TRANSPORT FOR LONDON

M25 JUNCTION 28 IMPROVEMENTS – COMMENTS ON RESPONSES TO EXAMINING AUTHORITY’S WRITTEN QUESTIONS 1 AND RESPONSES MADE AT DEADLINE 2

DEADLINE 3A: 18 FEBRUARY 2021

Client		Project		GROVE FARM ACCESS, JUNCTION 28 M25 NORTHBOUND SLIP LANE	
MR L JONES & MRS K JONES		Title		ACCESS ALTERATIONS TO GROVE FARM	
Status	Drawn	Scale	Sheet Size	Date	Drawing No.
FOR APPROVAL	PL	1:1000	A3	JAN 2021	REDW-3396-110
				Rev

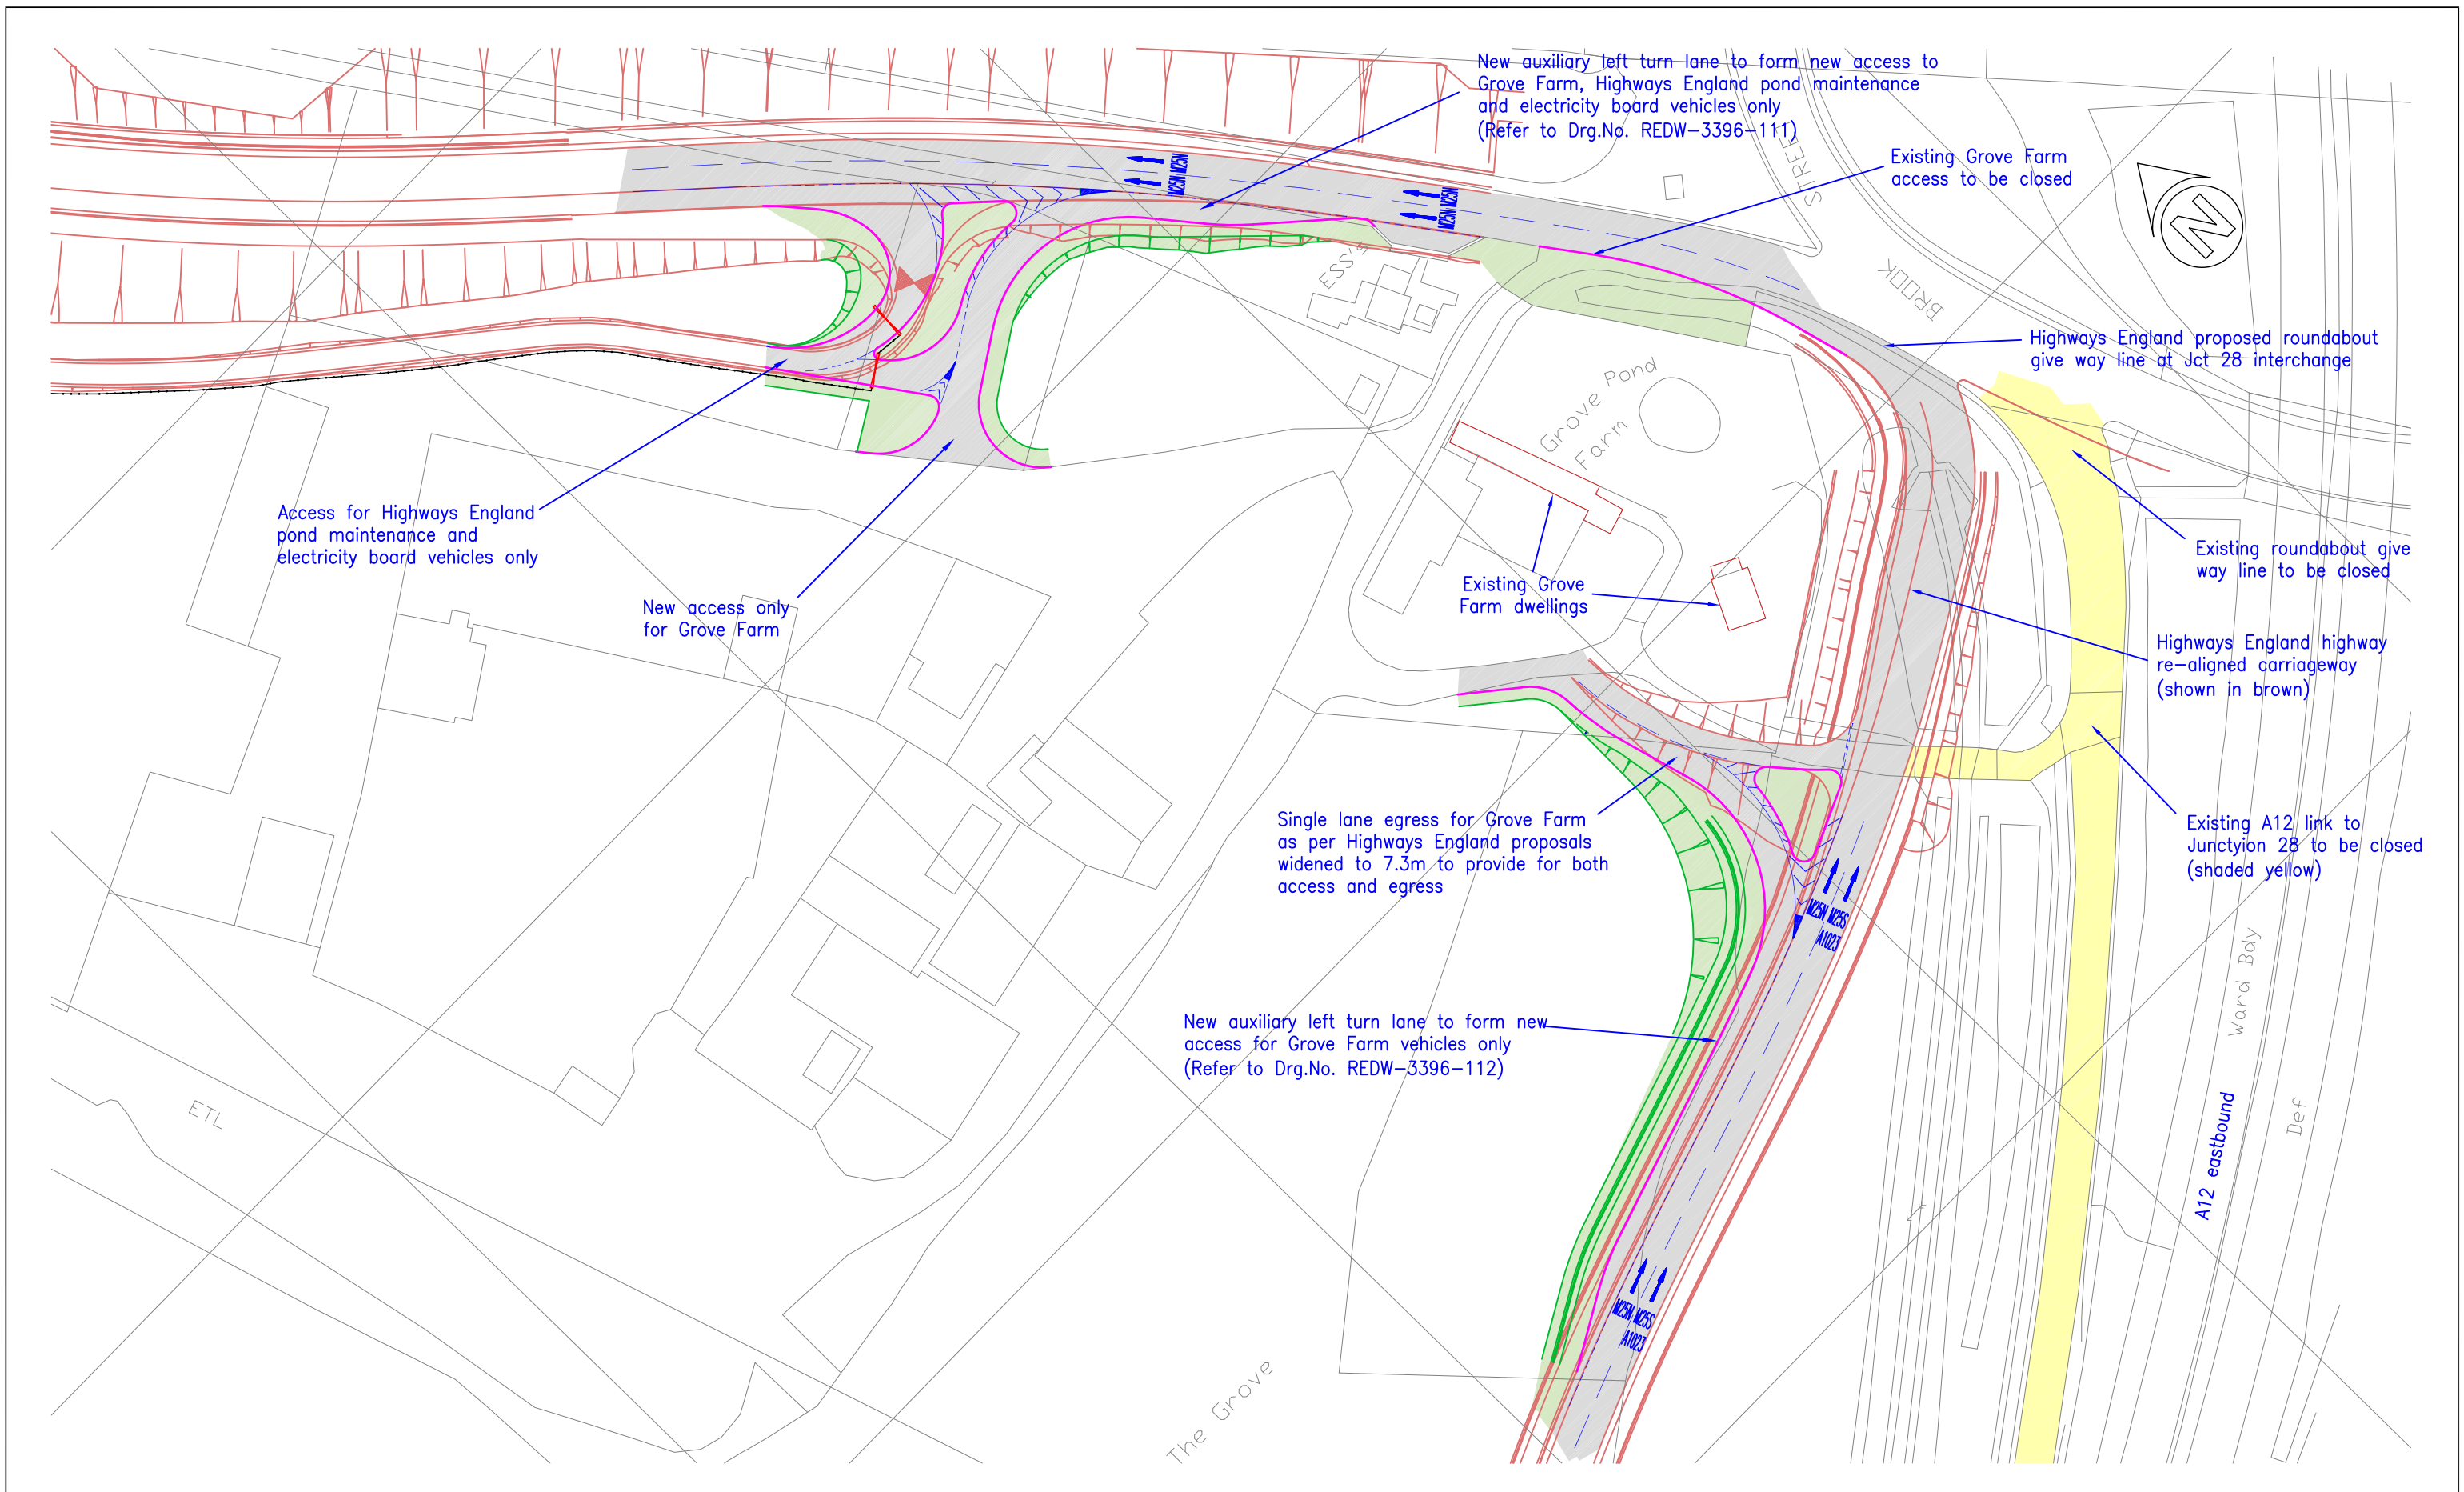
- 3.2 Work No. 15 of the draft DCO involves the re-provision of the egress route from Grove Farm onto the new AI2 eastbound off slip road. The draft DCO requires that TfL will be responsible for the ownership and maintenance of the new slip road.

- 3.3 The Written Representation from Grove Farm includes proposals for access to the farm to be provided from the new A12 eastbound off slip road as well as from the M25 northbound on slip road, with a new auxiliary lane on the left of the A12 eastbound off slip road providing this access. TfL wishes to understand the Applicant’s views on this proposal and TfL reserves its position until it has a fuller understanding of the implications including any road safety impacts. TfL does not seek to take on further maintenance liabilities beyond those already imposed by the draft DCO.
